Ref: 6/2024/0071/HOUSE
Date: 13/02/2024

HISTORIC BUILDINGS AND CONSERVATION ADVICE

RE: 38 Barleycroft Road Welwyn Garden City AL8 6JU

2 38 Barleycroft Road
Roof plan 1:100

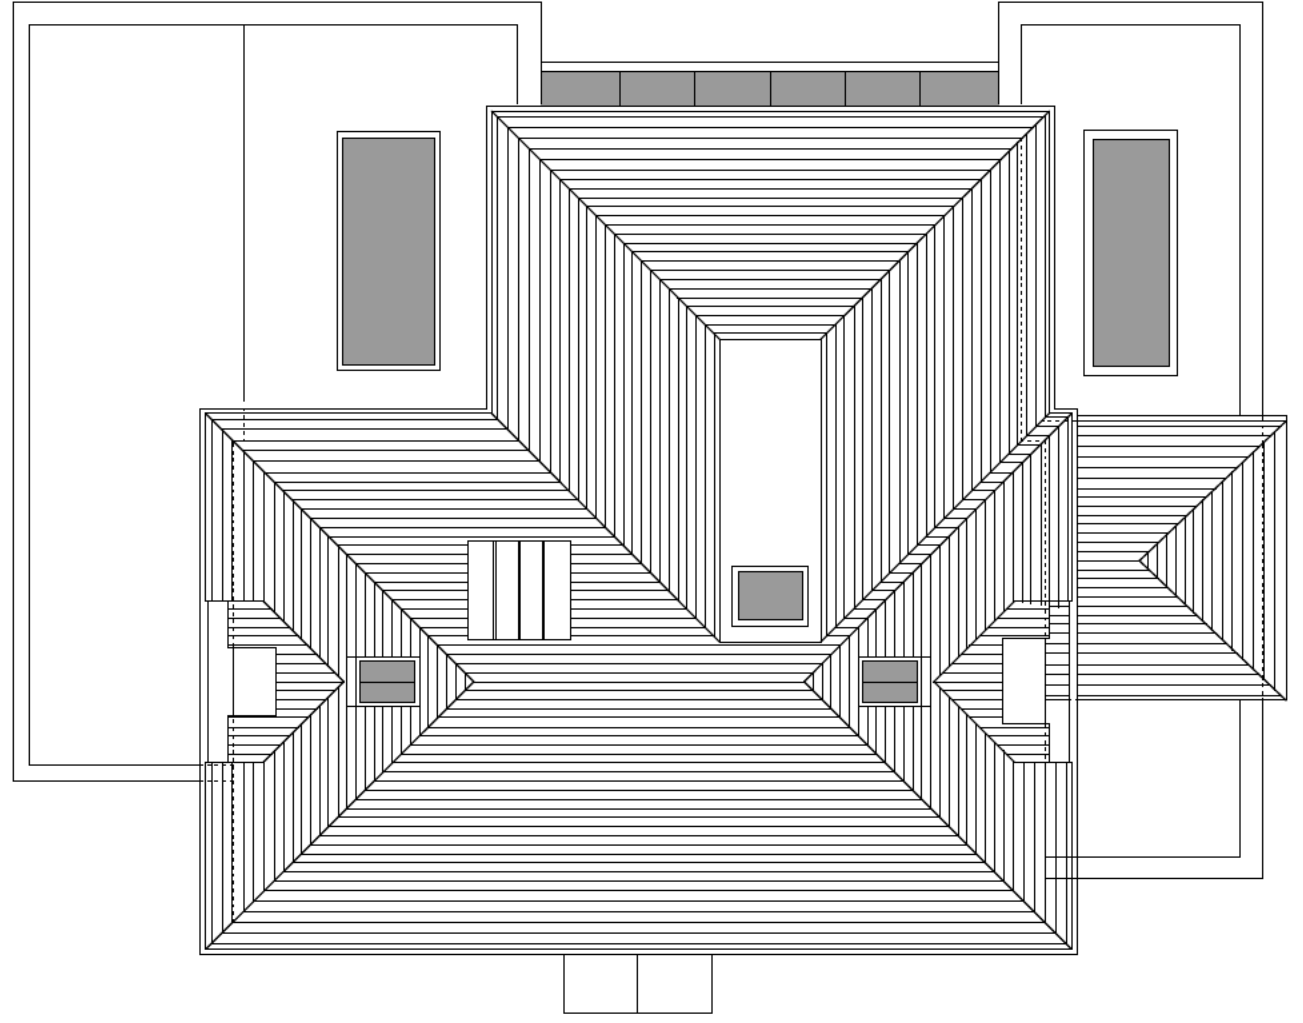
There would be no principle objection to a two-storey rear extension. However, the proposal would introduce an untraditional crown roof area which would not relate well to the traditional duo-pitched form of the host. I recommend that the two-storey roof form is amended. Rooflights to the flank roof slopes would not be supported in principle, these would be visible within the streetscene and would be an uncharacteristic feature that would not preserve the unadorned, traditional roofscape. The annotations indicate that the roof covering would be replaced; the existing rooftiles may be original and there are concerns regarding the loss of historic fabric.

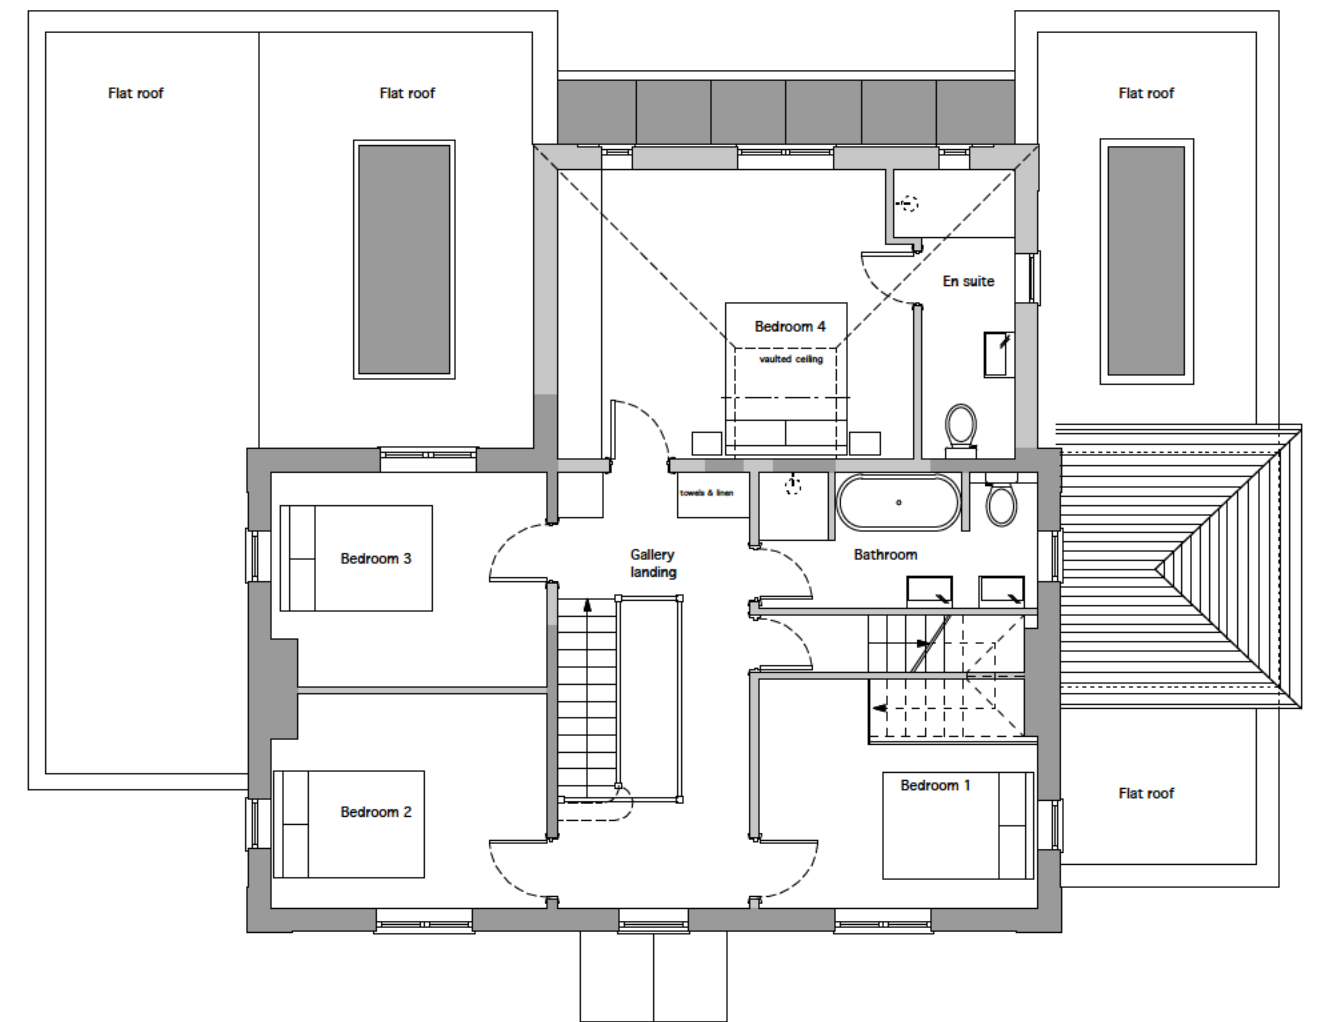
There would be no principle objection to extending the property at single storey. The single storey, hipped side extension appears to be an original extension as it is present on the other properties that are of the same design. The 1970s sunroom extension to the front of the single storey hipped roof element is not a positive addition as it infills the space between the hipped extension and front building line, undermining the set-back position of the hipped extension and consistency of the group. There are concerns that the addition of the curved parapet would exacerbate the appearance of the front extension and would result in an awkward arrangement between the curved parapet and the hipped roof (this also applies to the relationship between the craft room rear extension and the hipped roof extension). A simple parapet to the front may be acceptable as this could improve the appearance of the existing flat roof, but the upstand should be kept to the minimum.
